Re: 615 Iron Townhouses
615 Iron Street SW
Traffic Circulation Layout
Architect's Stamp 02-25-2022 (K14-D225)

Based upon the information provided in your submittal received 03-02-2022, the above referenced plan cannot be approved for Building Permit until the following comments are addressed:

TCL

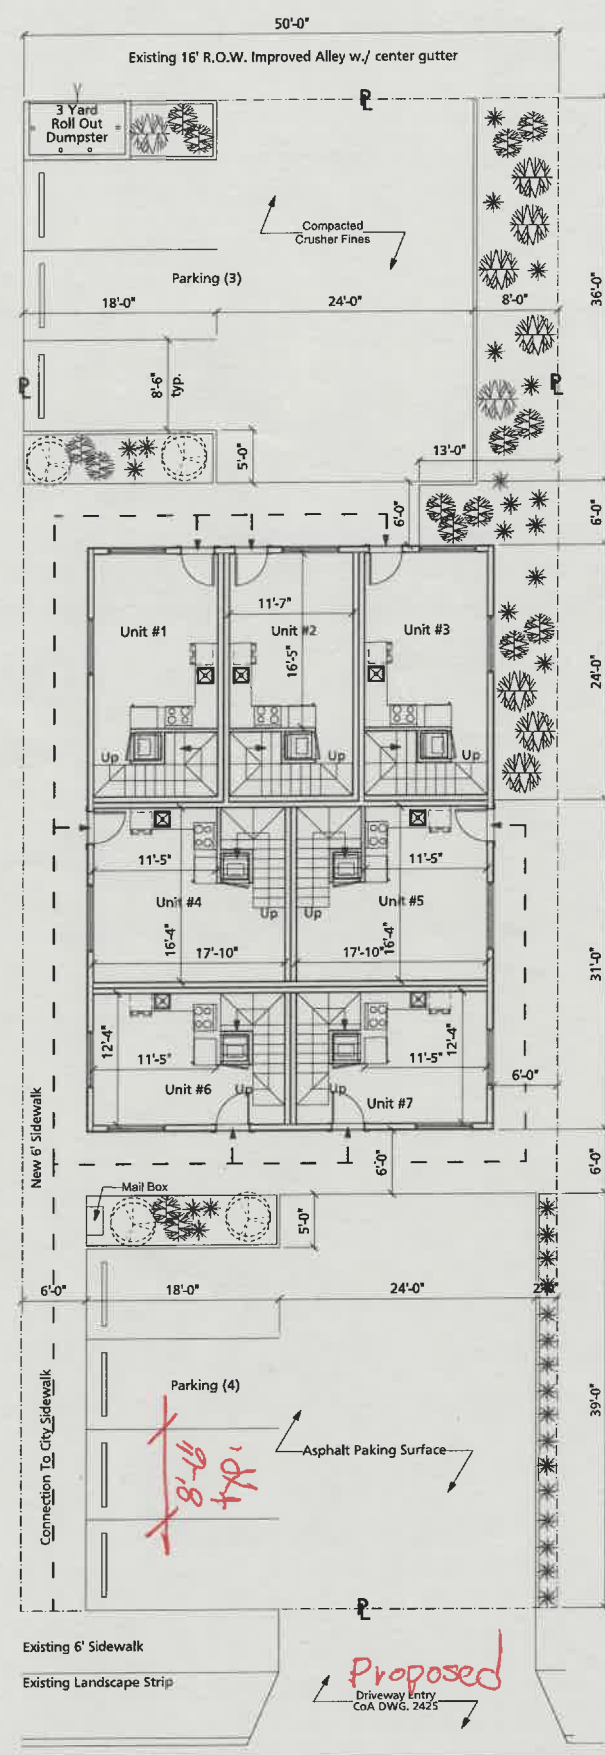
1. A scale of 1"=20' is recommended for sites less than 5 acres.
2. The scale must be shown on the plan. Per the Development Process Manual, Chapter 27, Section 2, Part B.1, on the following scales may be used:

1" = 20' 1" = 40'
1" = 50' 1" = 100' (for overall layouts only)
3. Landscaping and parking stall are in conflict. Please clear up this drafting concern.
4. Curbing should be installed to delineate landscape, and pedestrian ways and identify points of access. Please call out detail and location of barrier curb (**LABEL**).

5. Parking areas shall have barriers to prevent vehicles from extending over public sidewalk, public right-of-way, or abutting lots.
6. Provide a copy of refuse approval.

7. Fire Department: An approval Fire 1 plan needs to be provided (**IF APPLICABLE BY FD**).
8. Do you have a sidewalk connection from parking lot to townhouses? Please provide construction note for this concern.

9. It appears that your 6 ft sidewalk and landscaping are competing for the same space. Landscaping encroaching onto proposed sidewalk connection. Please address this concern.

10. Add a note stating "All broken or cracked sidewalk must be replaced with sidewalk and curb & gutter." A build note must be provided referring to the appropriate City Standard drawing (**2430 & 2415A**).
